ARCHITECTURAL RESPONSE

RE: Kelso Crescent Multi-Level Warehouse, Moorebank (SSD-58978472)

Response to Submissions

Drawing Title:  
**Landscape Detail Plan 2**  
DWG No:  
**SSD-03**

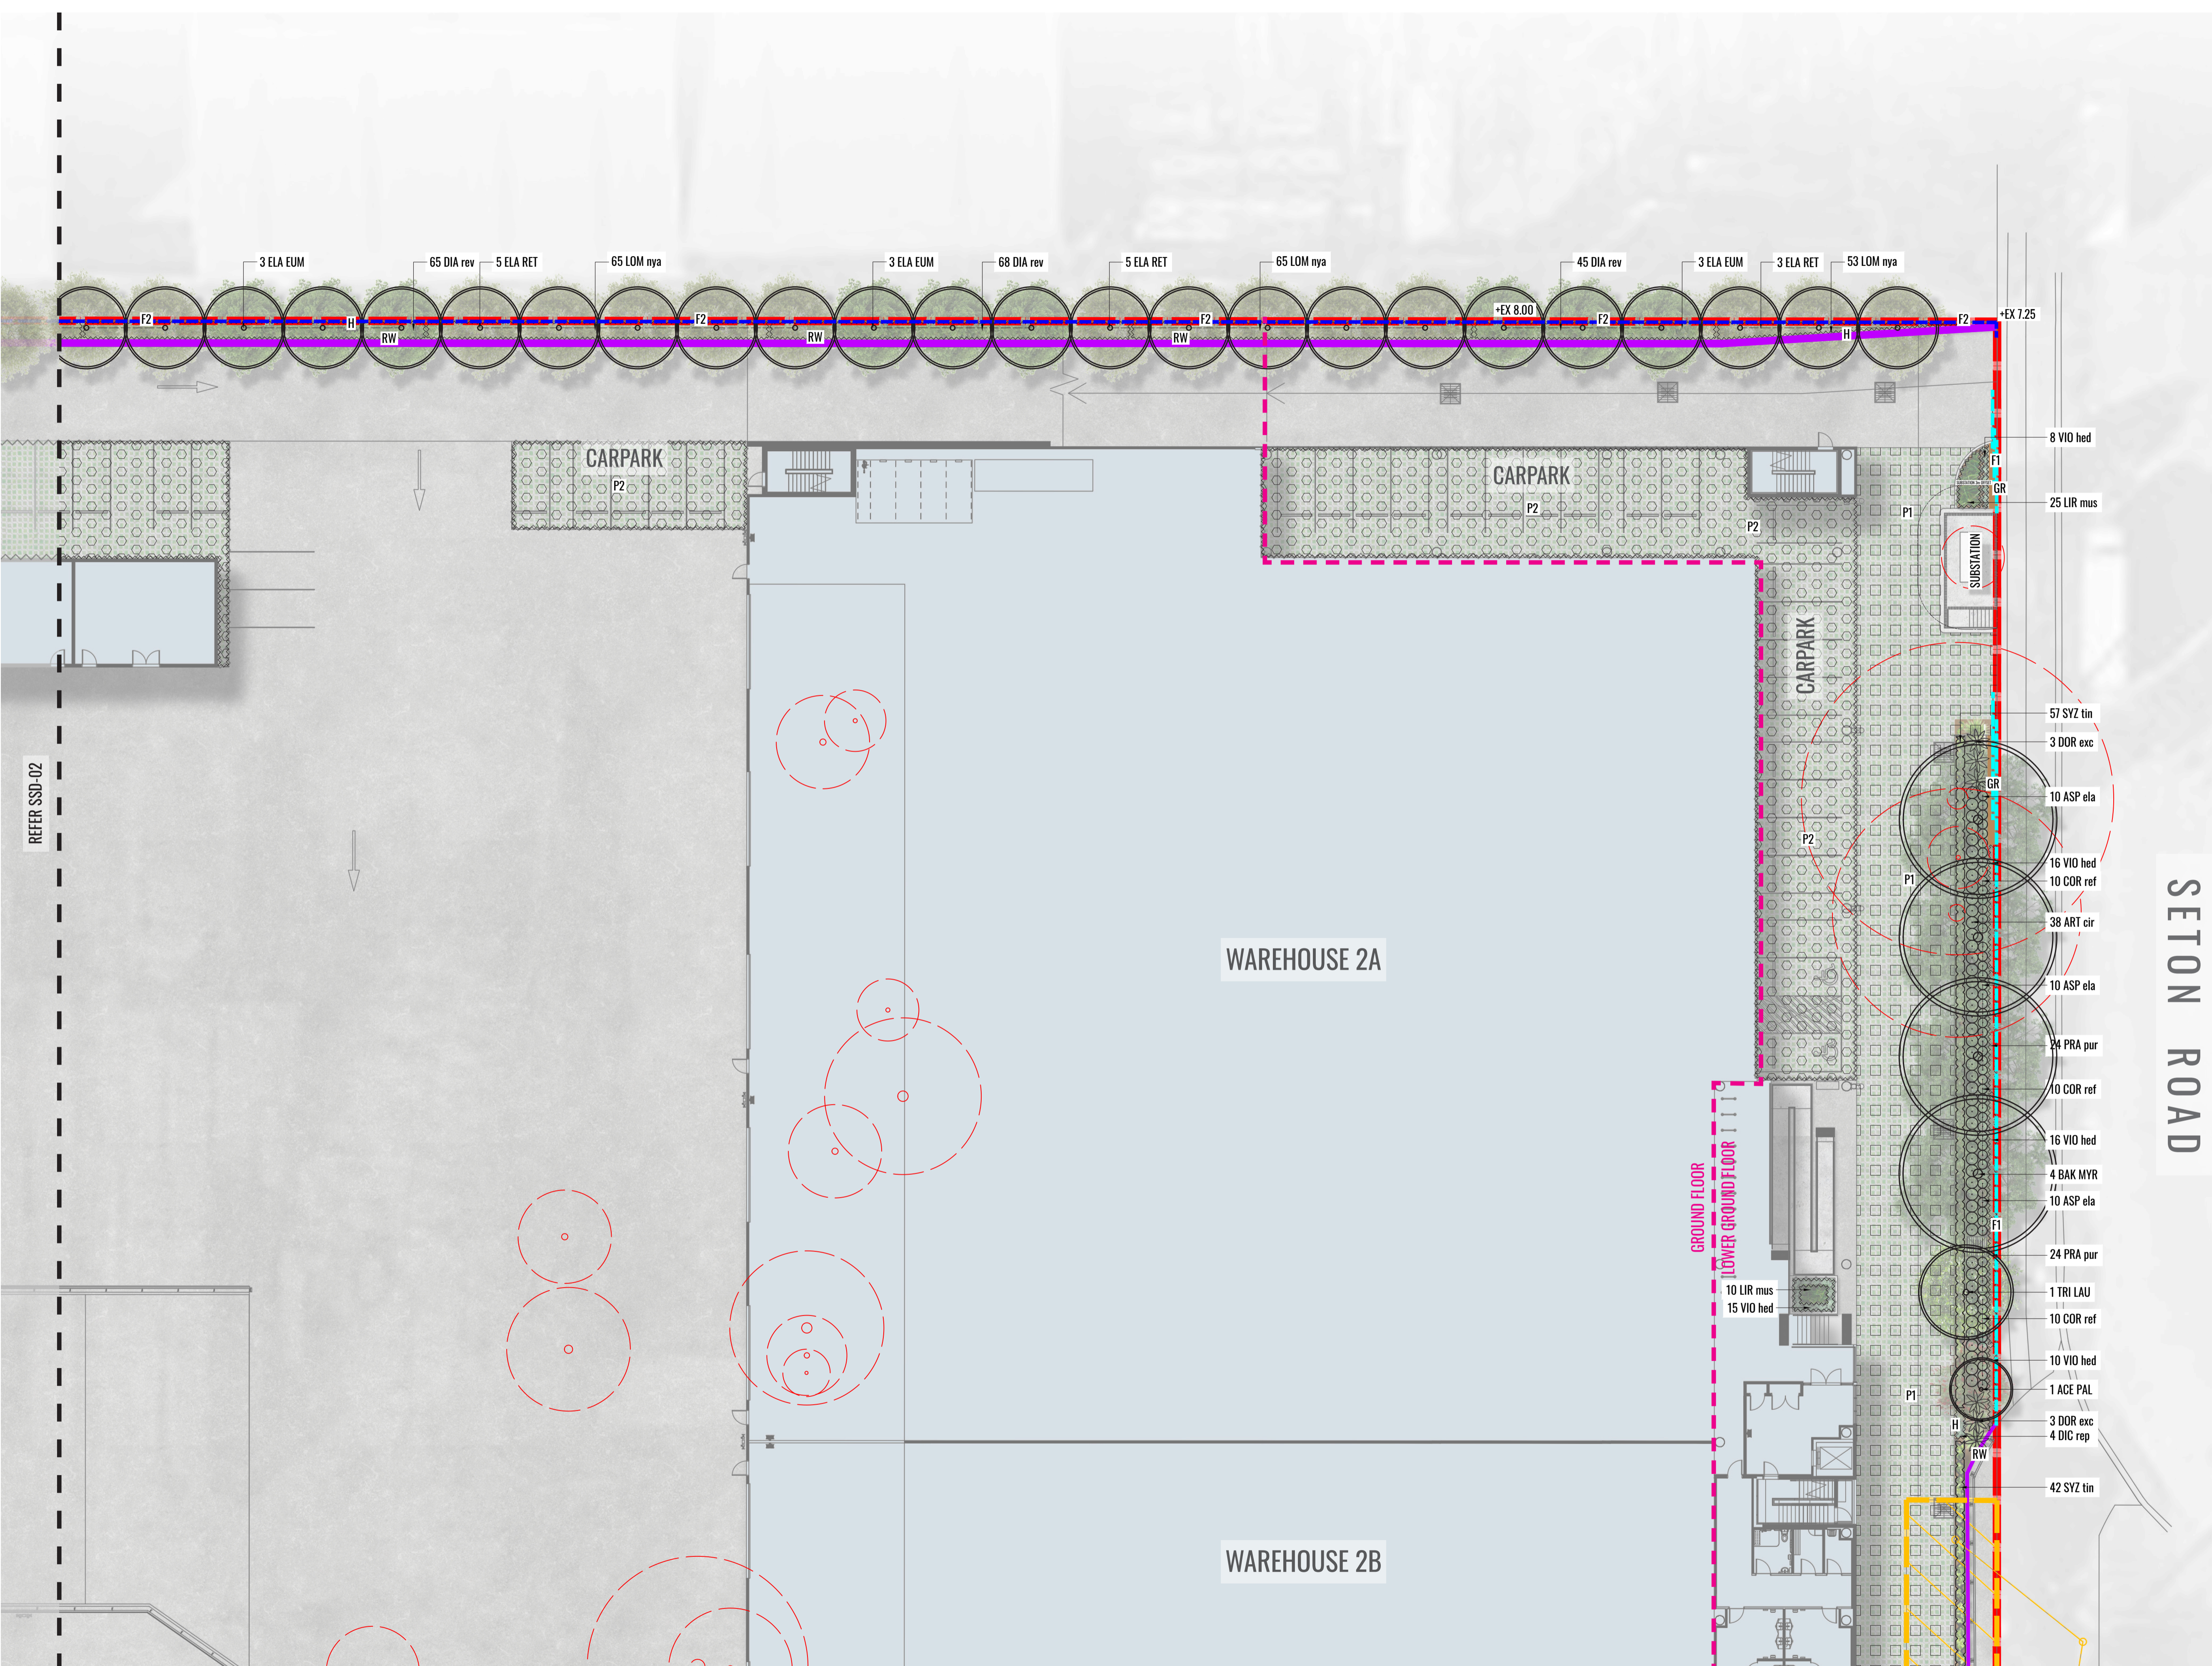
Tree Retention — Trees 15 and 17

Trees 15 and 17 are significantly sized (19m and 21m tall), mature native trees, both with good Health, Structure and Amenity value per the Arborist Report.

The Arborist report states 'Remove' against these trees with no justification why.

1. The Department acknowledges Council's concerns regarding landscaping, particularly in relation to the front setback to Seton Road, the proposed removal of Trees 15 and 17, and the reduction of soft landscaped area to **6% of the site (excluding permeable paving)**. Limited justification has been provided for the removal of Trees 15 and 17. The Department also notes that amendments to the proposal have resulted in car parking being located around the buildings, which has contributed to a substantial reduction in landscaped area. The Department requests that **opportunities be investigated to increase landscaping provision**, along the Seton Road frontage and, where feasible, to **retain Trees 15 and 17**.

The site configuration facing Seton Road has been re-designed; including adjustments to proposed RLs, reconfiguration of the carparking, changes to the proposed structural design of the building and landscaping changes – to enable retention of the significant Trees 15 and 17.

The re-design of the Seton Road frontage has allowed for the retention of Trees 15 and 17, and the introduction of additional soft landscaping areas and additional new trees.

scale	As indicated	A1
project no	250211	
date	08.10.25	
dwn	dwg no	issue
DC	250211 - DA-112	A

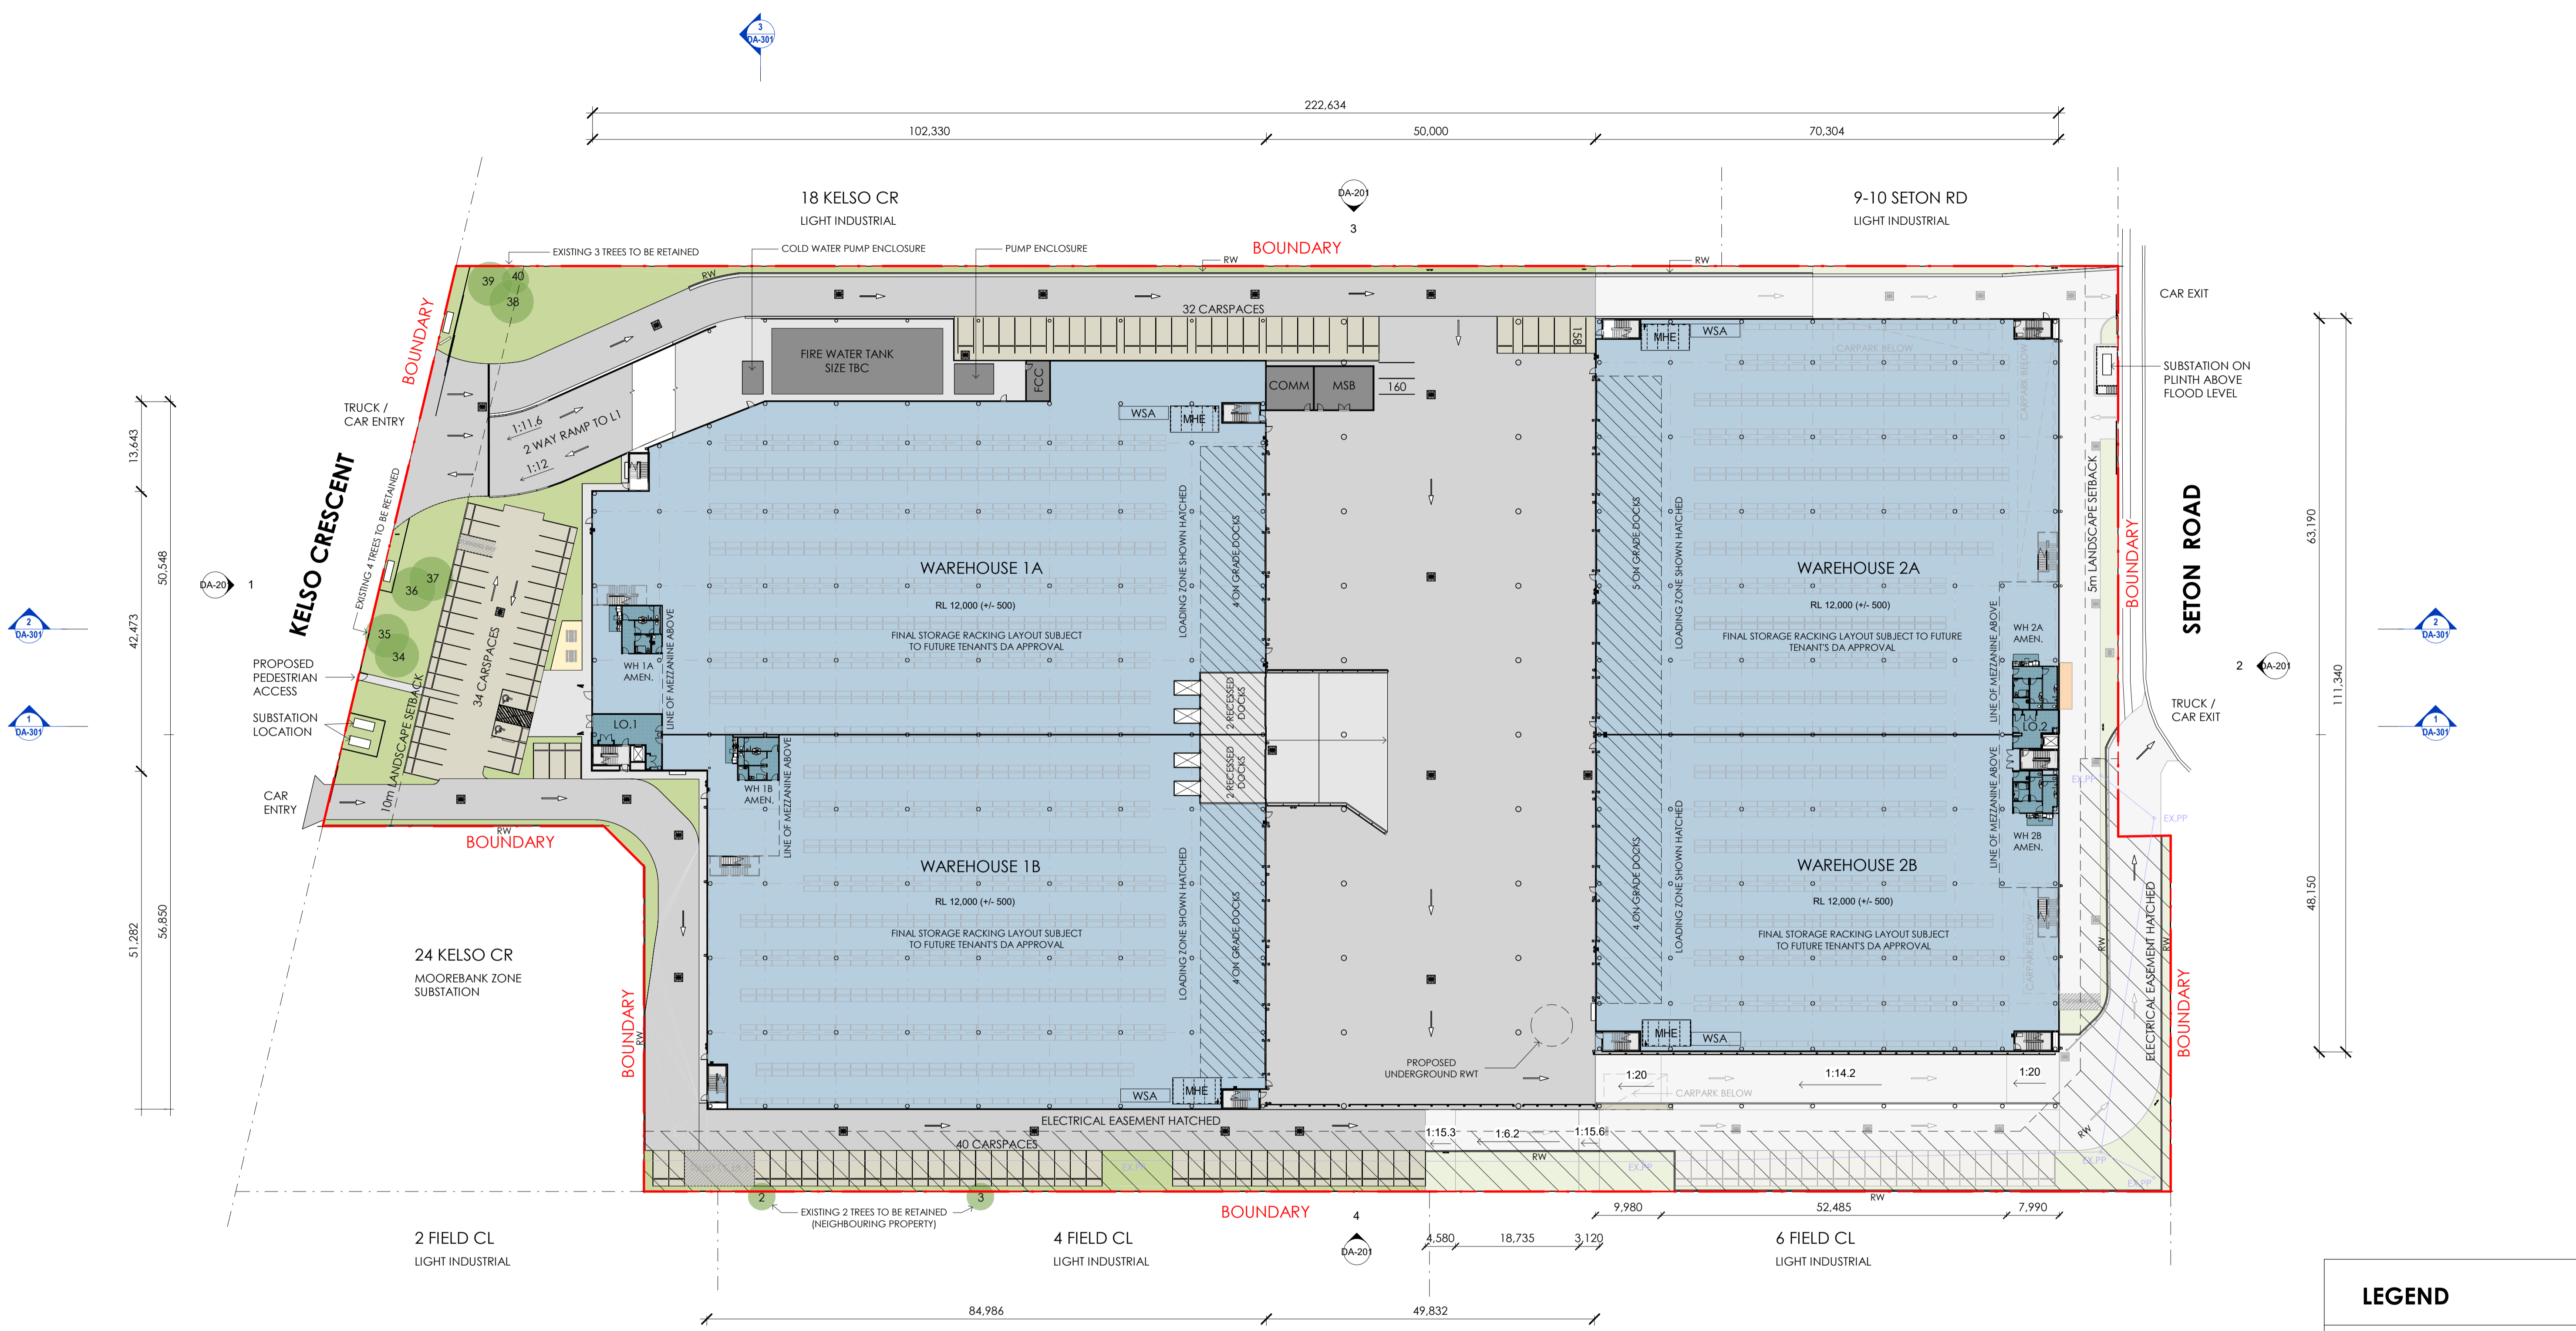
Issue:**Pedestrian Entry Safety**

- *The pedestrian entry is not far from the driveway but runs straight through the car park — this is not a safe or appropriate way to enter a main entry of a building.*
- *The main entry foot path should be reconfigured to enable a direct connection to the main entry, with enough separation from the driveways and not having to walk through a car park and conflict with vehicles.*

4. *The Department acknowledges Council's concerns regarding pedestrian access within the site and further highlights issues related to **pedestrian connectivity from the parking areas to workplace entrances**. Specific concerns are raised regarding the proposed parking adjacent to the eastern entry of the heavy vehicle loading/unloading hardstand area, as well as parking along the western boundary. It remains unclear how employees are expected to safely access their workplaces from these areas. The Department requests that **clearly defined and safe pedestrian access routes be incorporated into the design and explicitly shown on the plans**.*

The approach to the main entry from Kelso Crescent across the small front carparking area has been more clearly delineated and defined from the carpark by means of configuration, alignment and line marking.

Defined pedestrian pathways, line-marking and protection devices have been shown and/or labelled on the updated plans; additionally the proposed warehouse staff entrances (and pedestrian access to these) have been marked on the plans in addition to the office and main building entry points.
